**From:** Laura Gibbons  
**Sent:** 02 January 2019 16:33  
**To:** Planning.Responses <[Planning.Responses@arun.gov.uk](mailto:Planning.Responses@arun.gov.uk)>  
**Cc:** Simon Davis <[Simon.Davis@arun.gov.uk](mailto:Simon.Davis@arun.gov.uk)>  
**Subject:** RE: Planning Consultation on: BR/311/18/PL

Engineers Comments Regarding Surface Water Drainage

**APPLICATION** **BR/311/18/PL**

**Description of Works:** Erection of 176 bedroom student accommodation building with associated hard & soft landscaping. This application may affect the setting of listed buildings, may affect the character & appearance of the Upper Bognor Road, Mead Lane Conservation Area & is a Departure from the Development

Summary of Critical Results by Maximum Level (Rank 1) for Existing

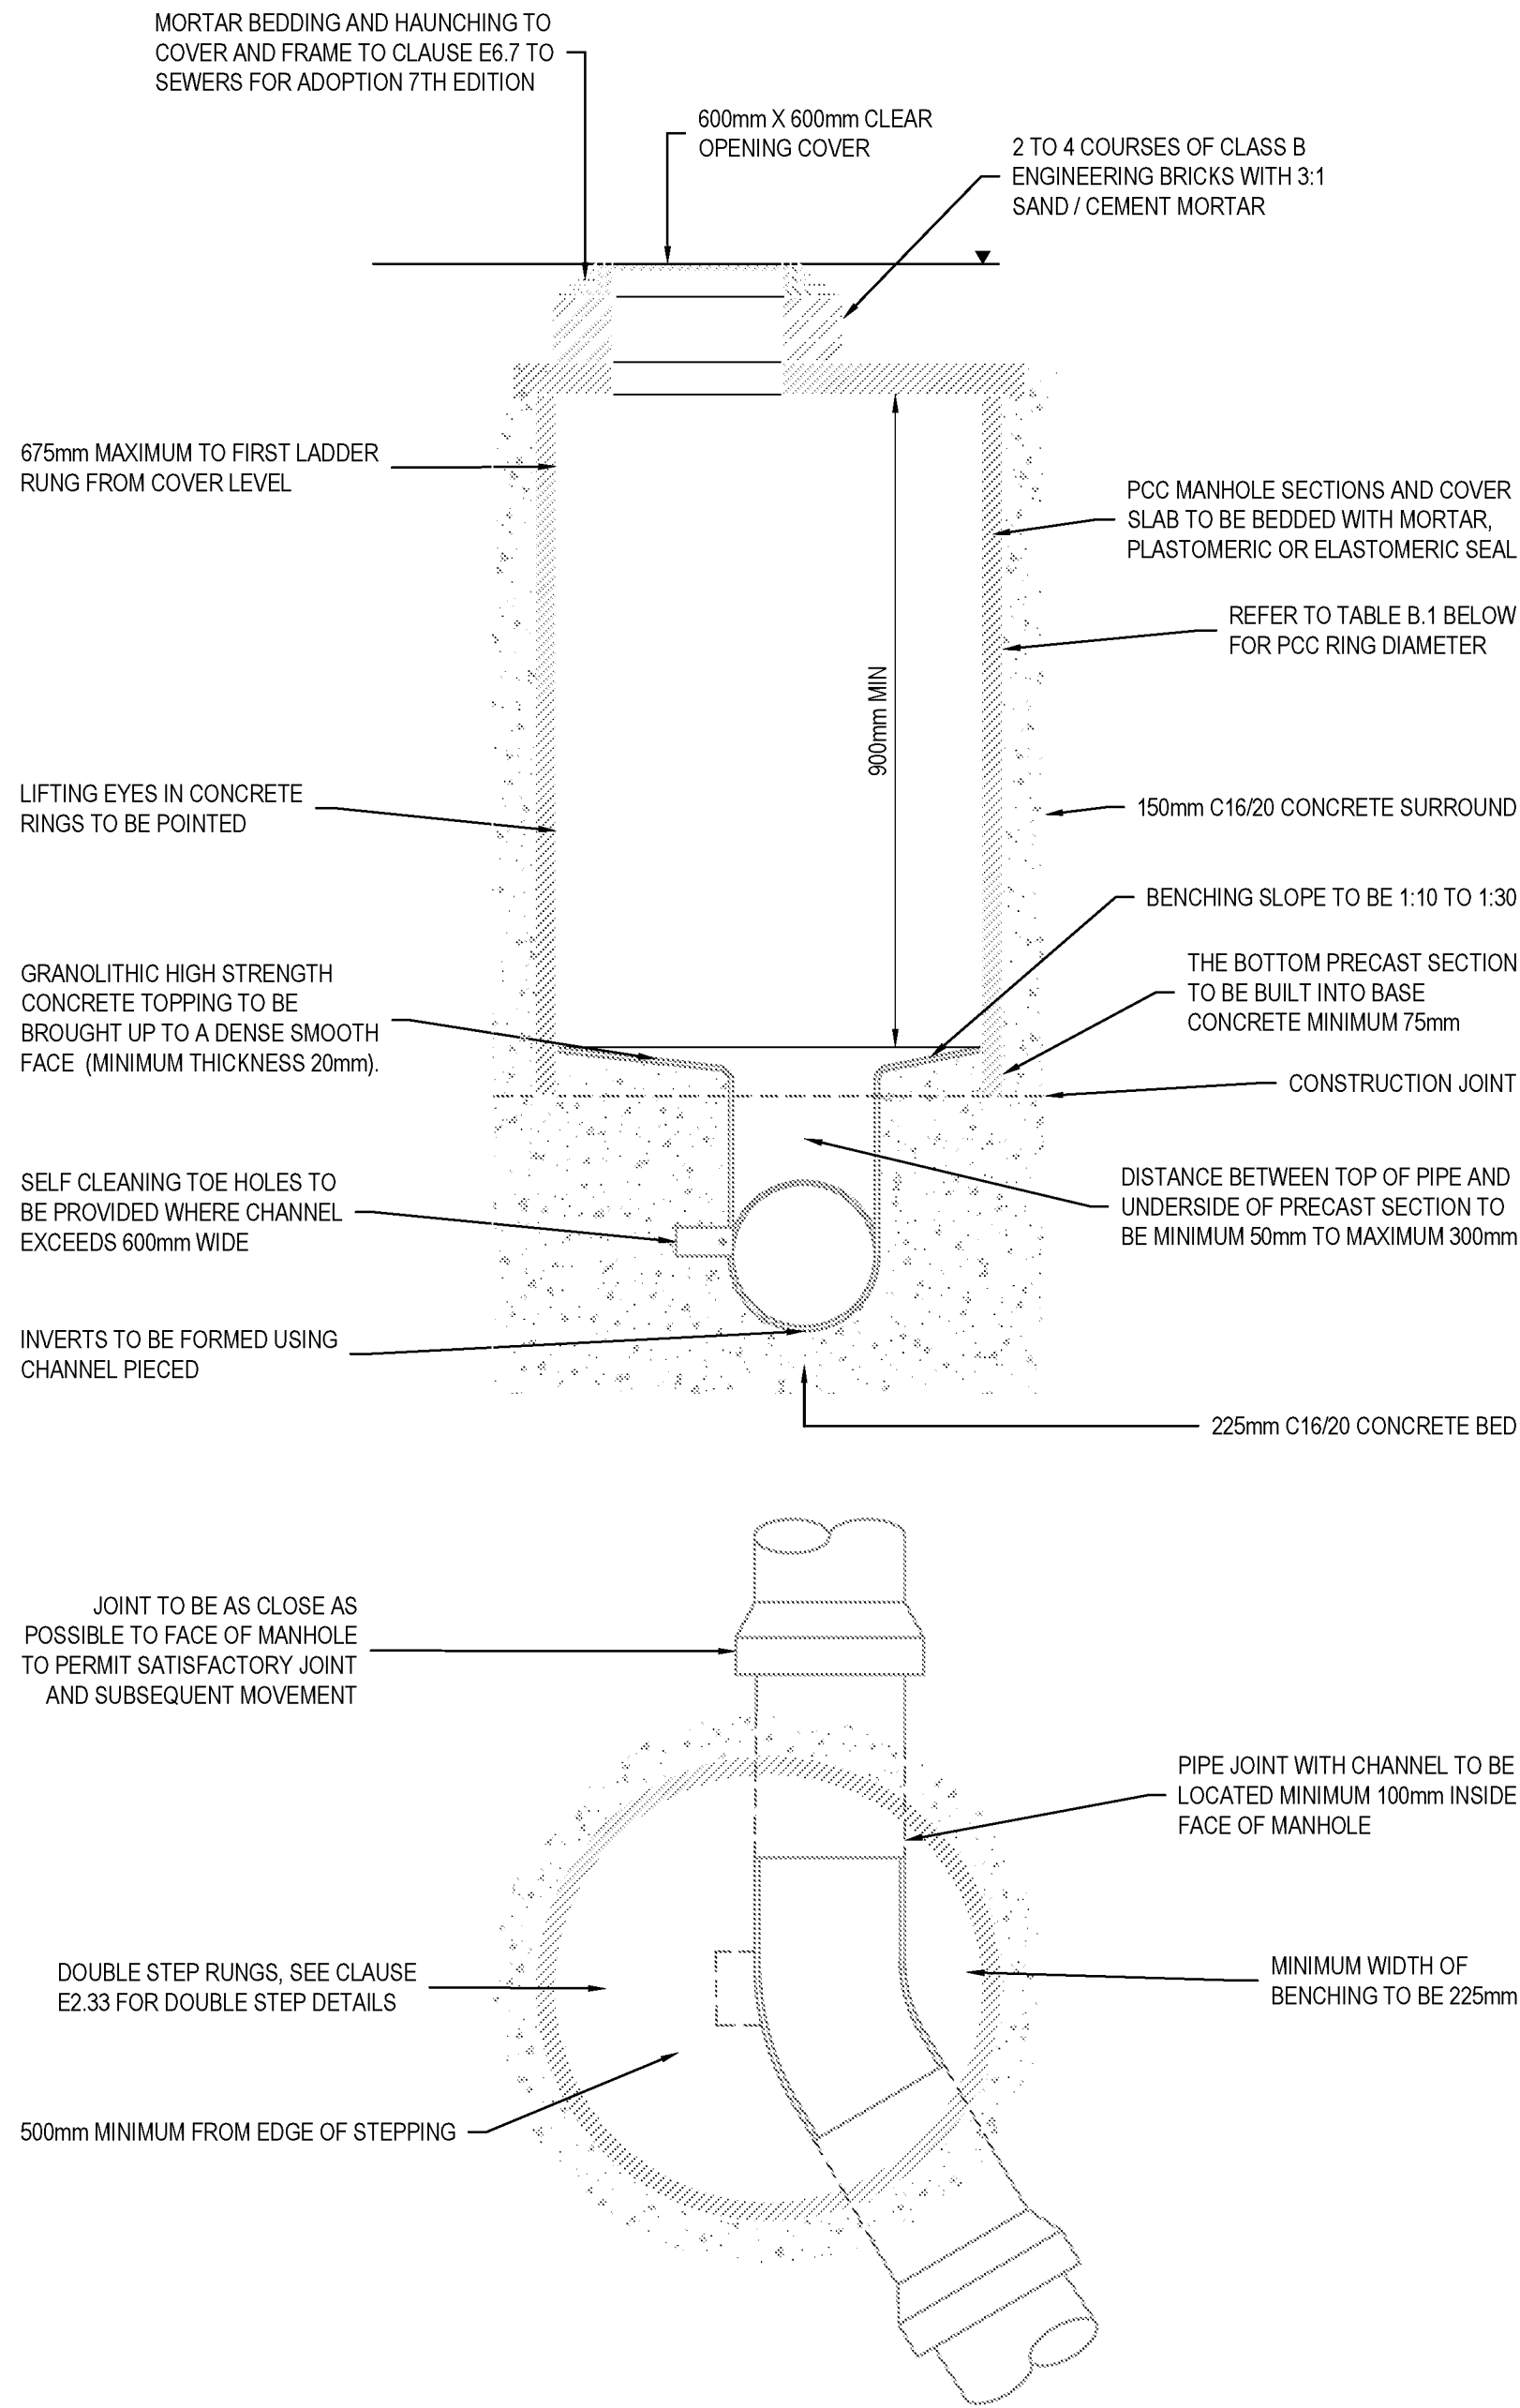
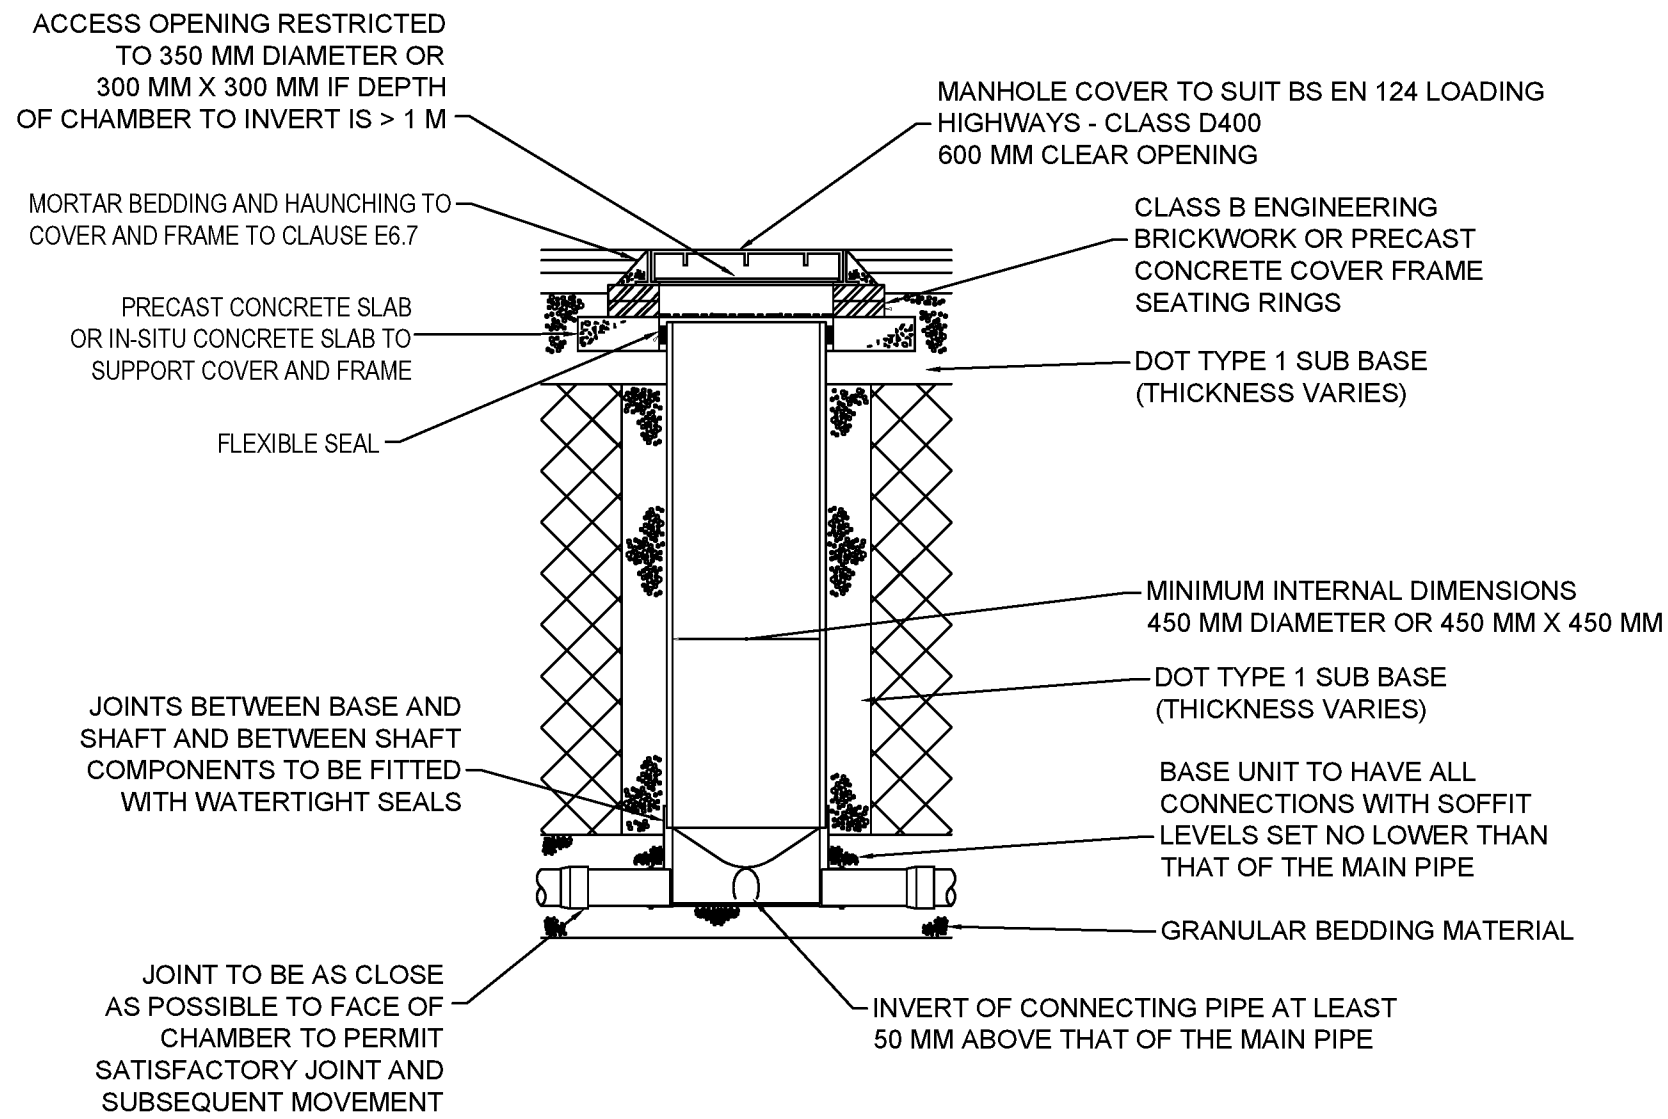
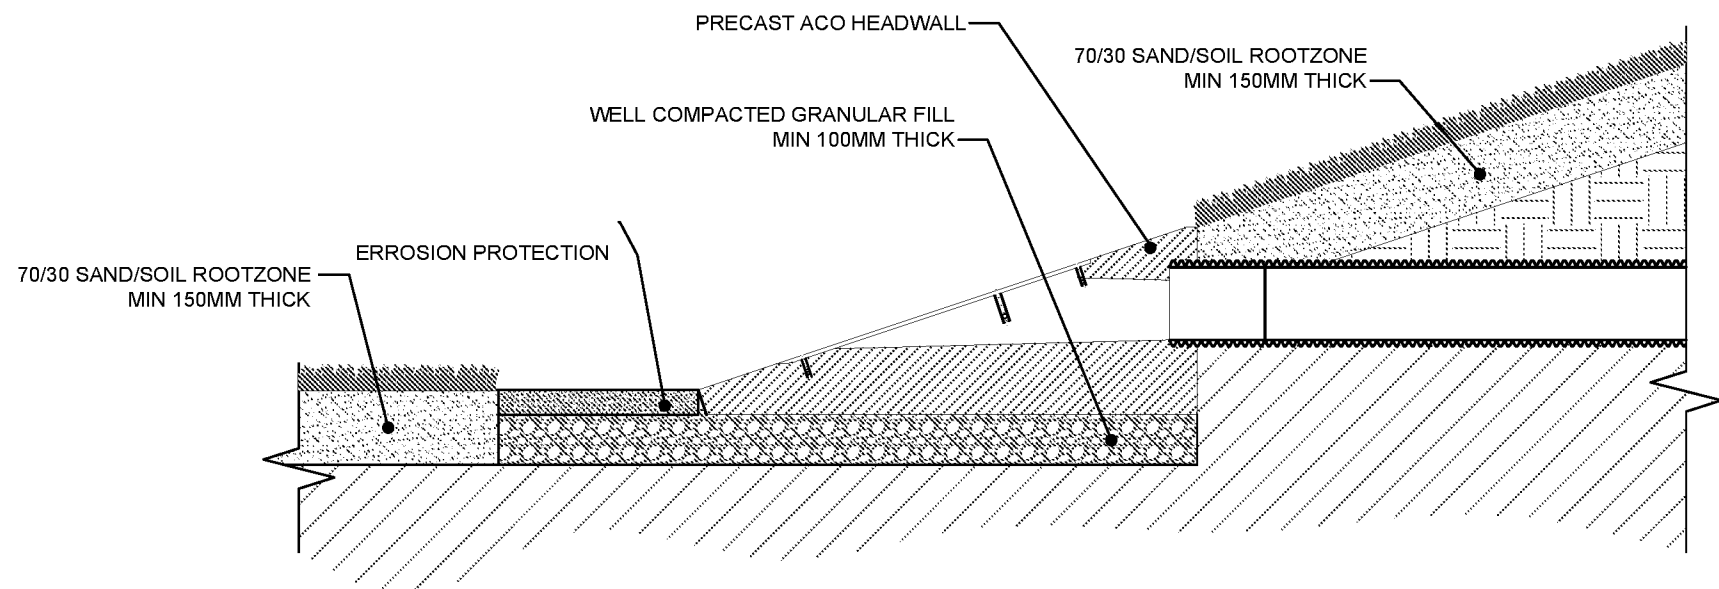
The proposals are to limit discharge to 5l/s. This is not appropriate, discharge should be restricted to either QBar or 2l/s whichever is the greater. 2l/s is achievable without increasing the risk of blockage to unacceptable levels.

Furthermore, the development is within a surface water flood risk area. The attenuation basing should be designed to accommodate the surface water flooding displaced by the proposed building and the rain water from the proposed impermeable areas.

- SITE BOUNDARY
- EXISTING POTABLE WATER PIPE WITH EASEMENT
- EXISTING FOUL WATER PIPE WITH EASEMENT
- EXISTING CULVERTED WATERCOURSE

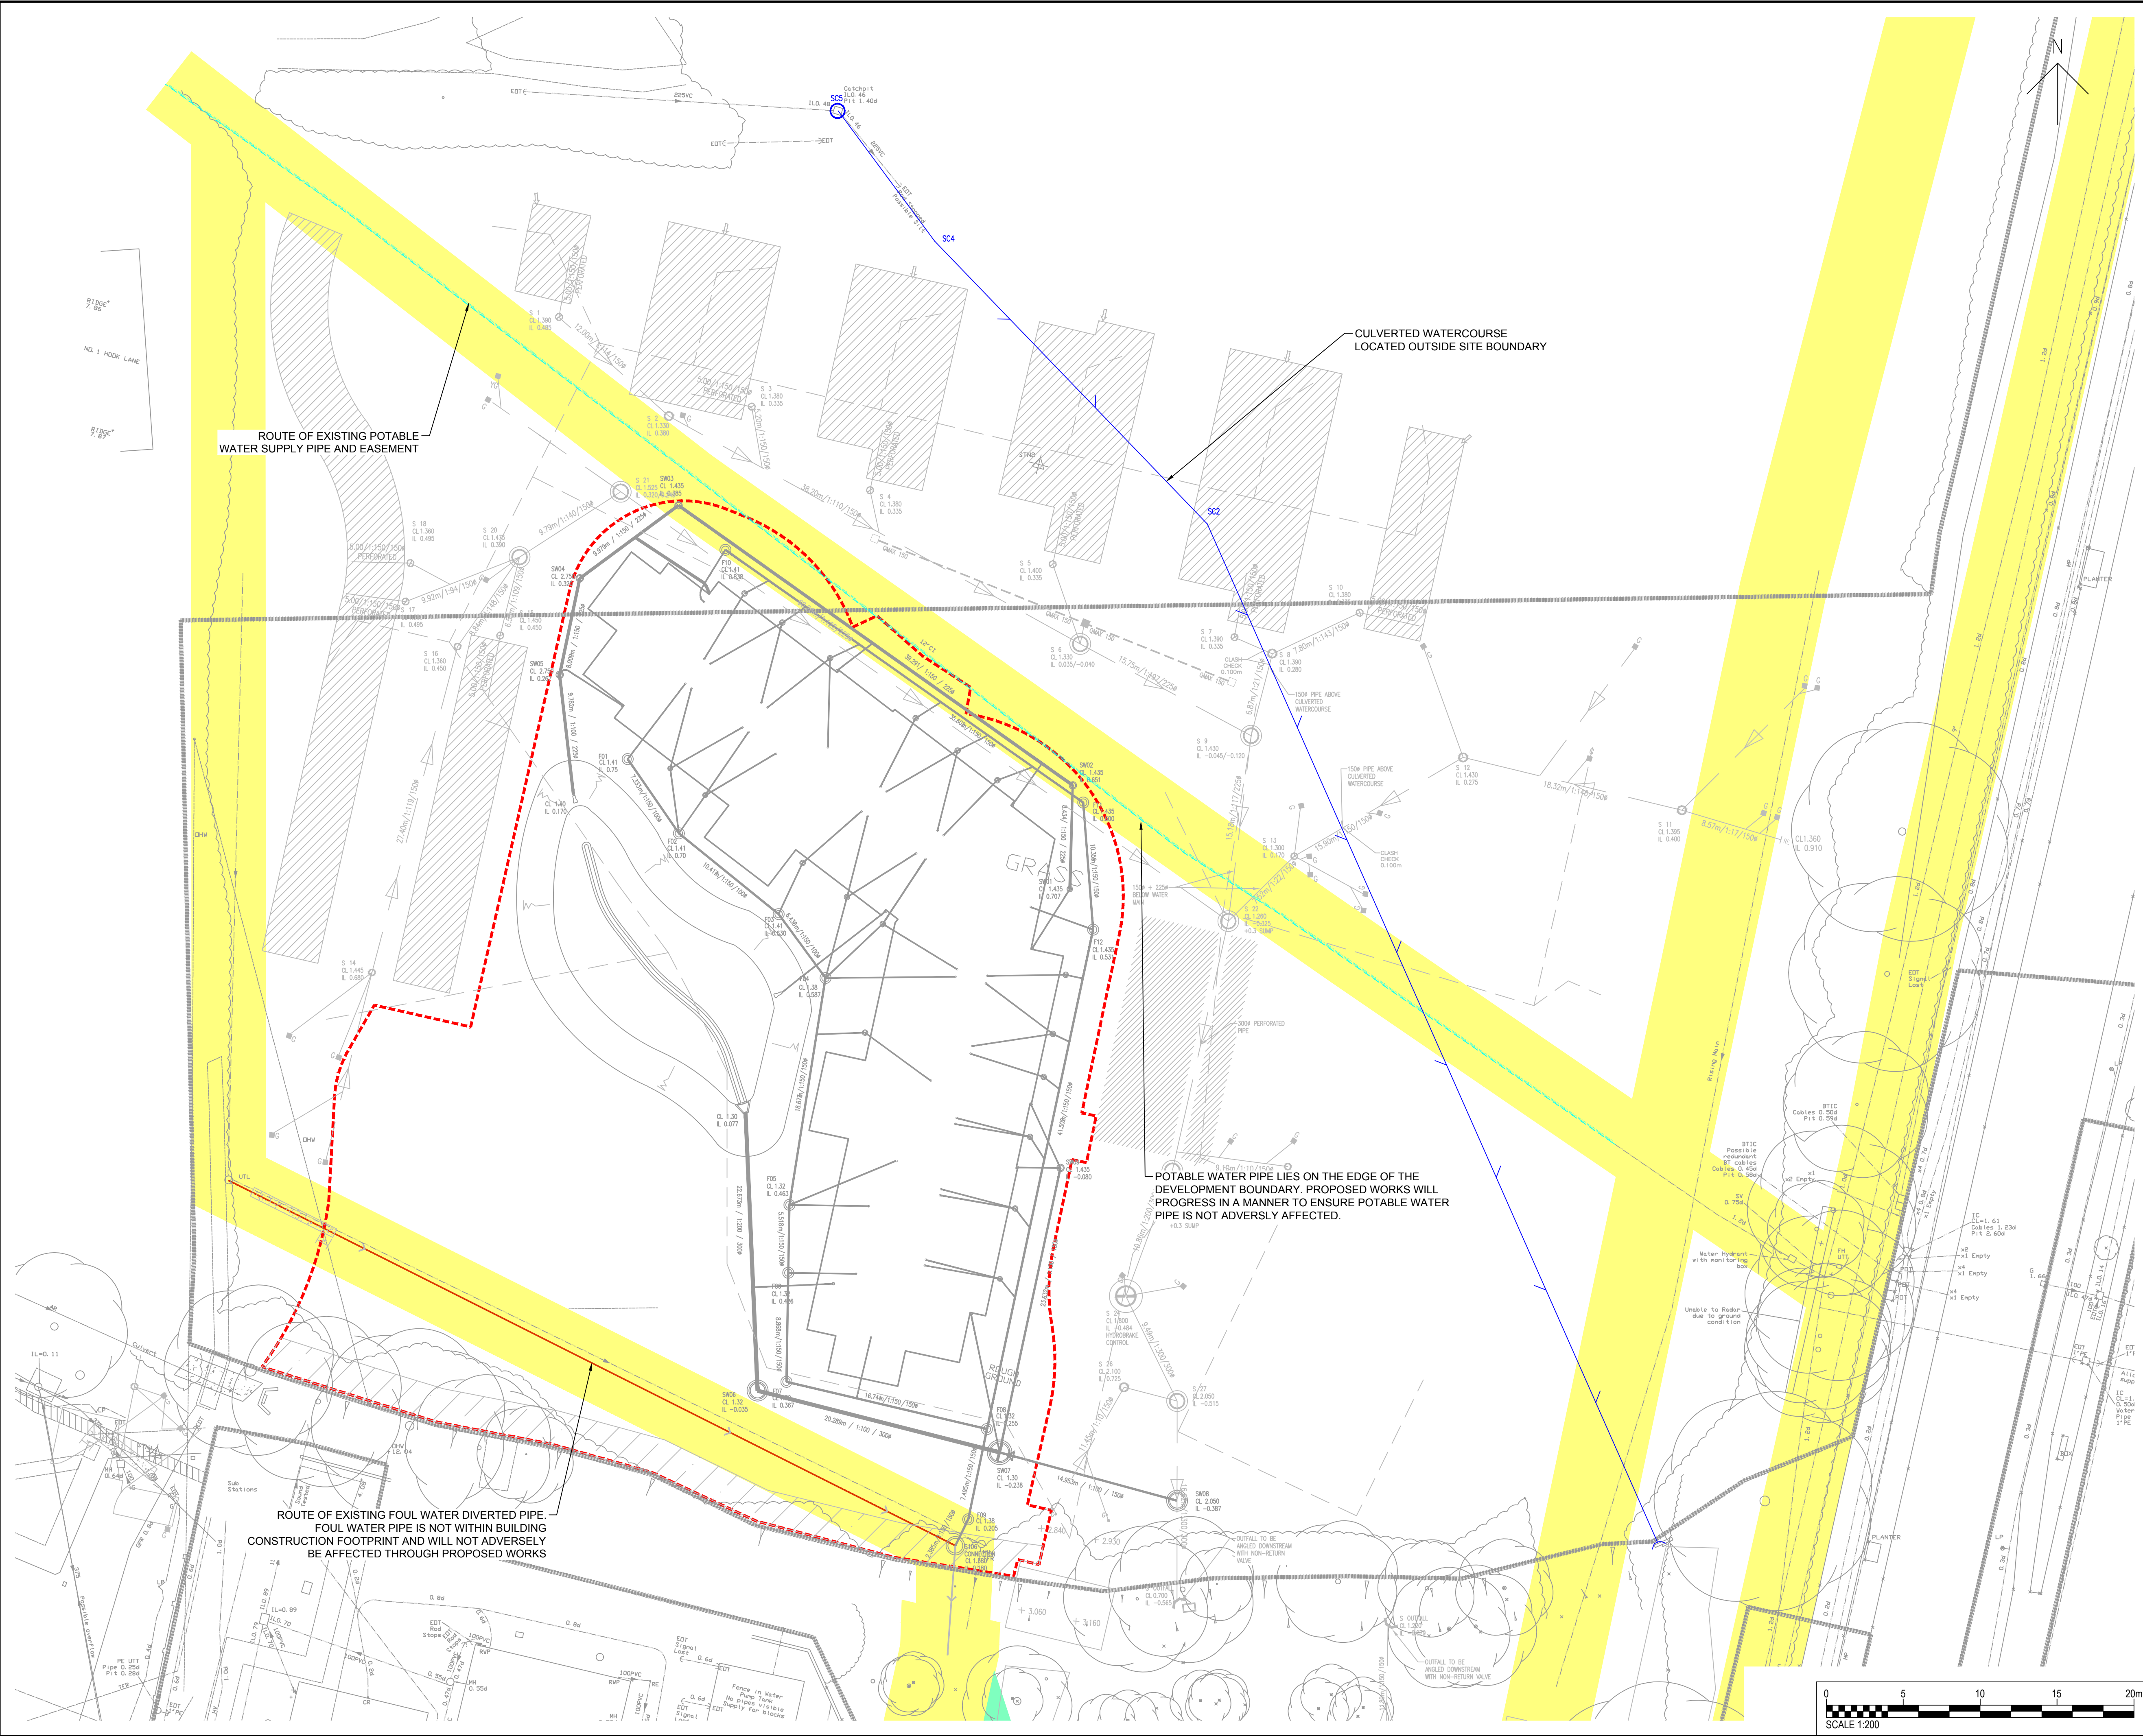
There is a private sewer running through the site which is in a poor state of repair. The applicant has been in consultation with us regarding this previously. The corrective measures identified must be undertaken. The derelict culvert that is also present in this area should be removed, the applicant is advised to contact us regarding this.
